**31005/APP/2024/1086 - 84 EAST ROAD**

**Rhian Thomas** <RThomas2@hillingdon.gov.uk>  
To: Jo Brough <paddingtonplanning@gmail.com>  
Cc: OSN Development Ltd <osn.development@yahoo.com>

2 July 2024 at 11:51

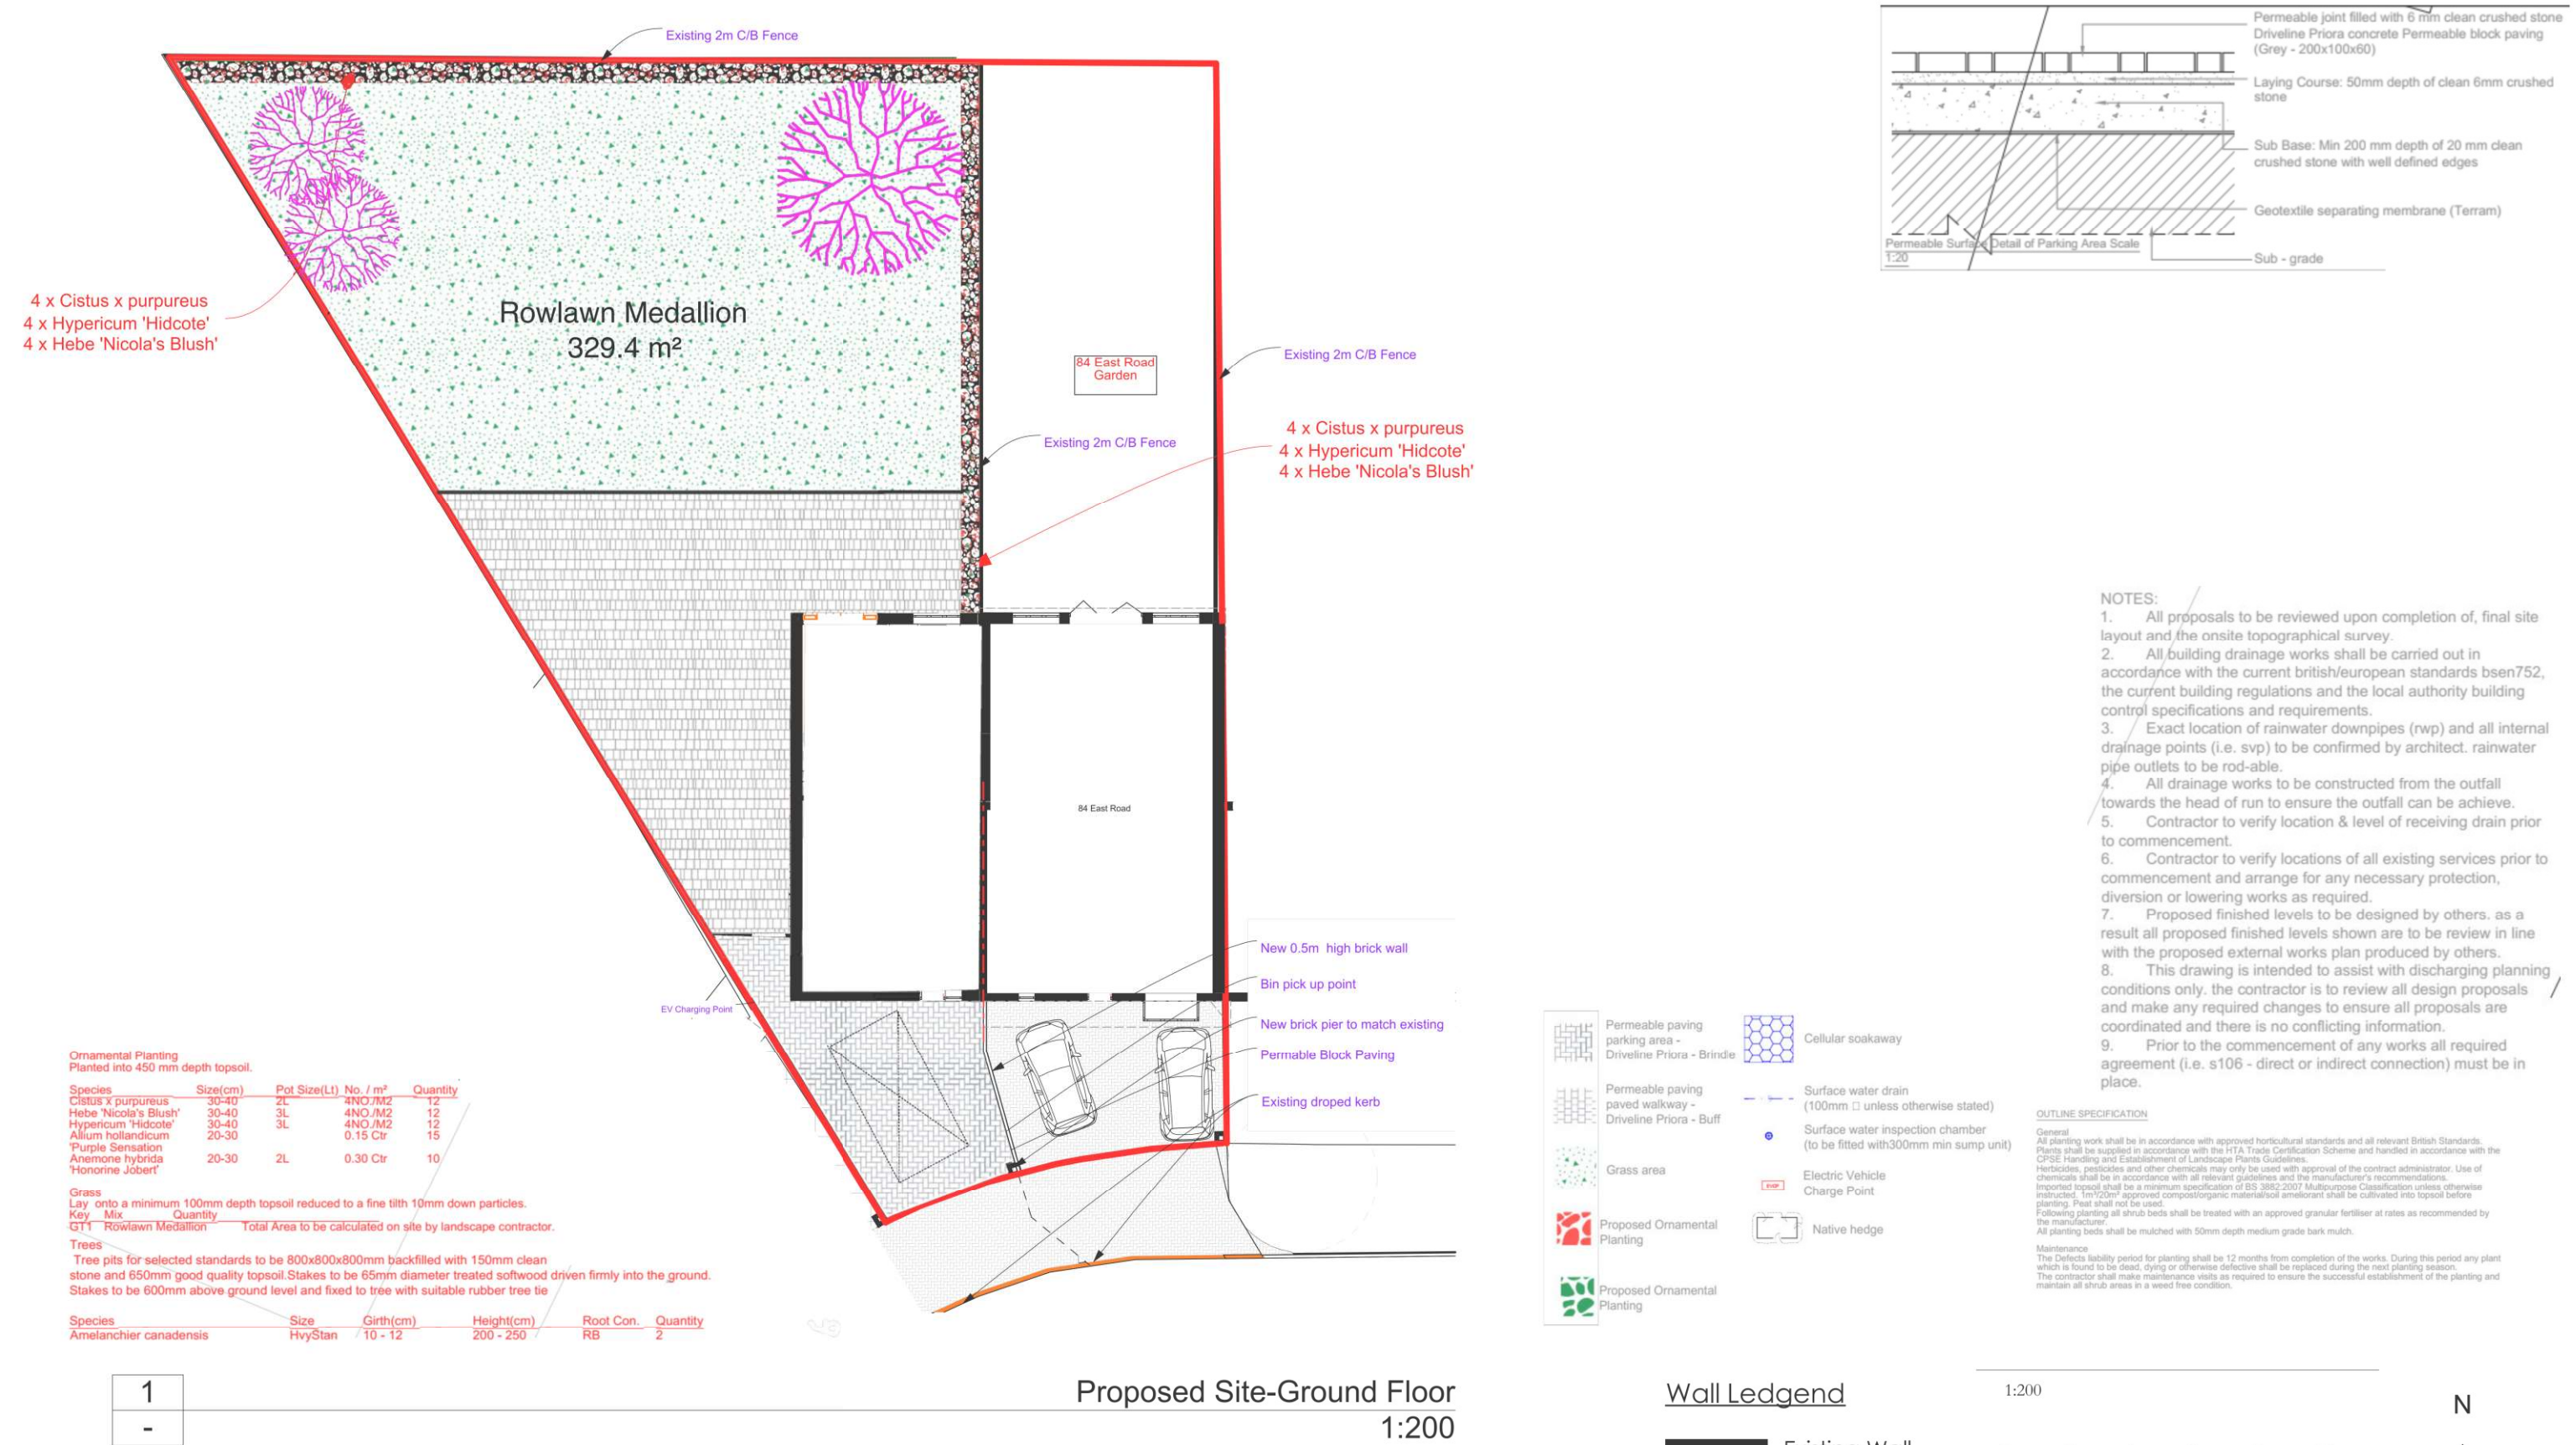
The character and appearance of the area is made up of dwellings with spacious gaps between blocks. The proposed development would close a very prominent gap between numbers 84 and 86 East Road. This was mentioned within the inspectors comments within appeal ref. APP/R5510/W/21/3277296 for a new dwelling at the site.

The new dwelling due to its design would make the already long row of terraces appear longer. It is noted that no. 78 East Road benefits from a two storey side extension. However, this has not been built in accordance to the approved plans which indicate that the extension should have been set down from the main ridge to break up the front elevation of the row of terraces, therefore we would not consider this as a precedent.
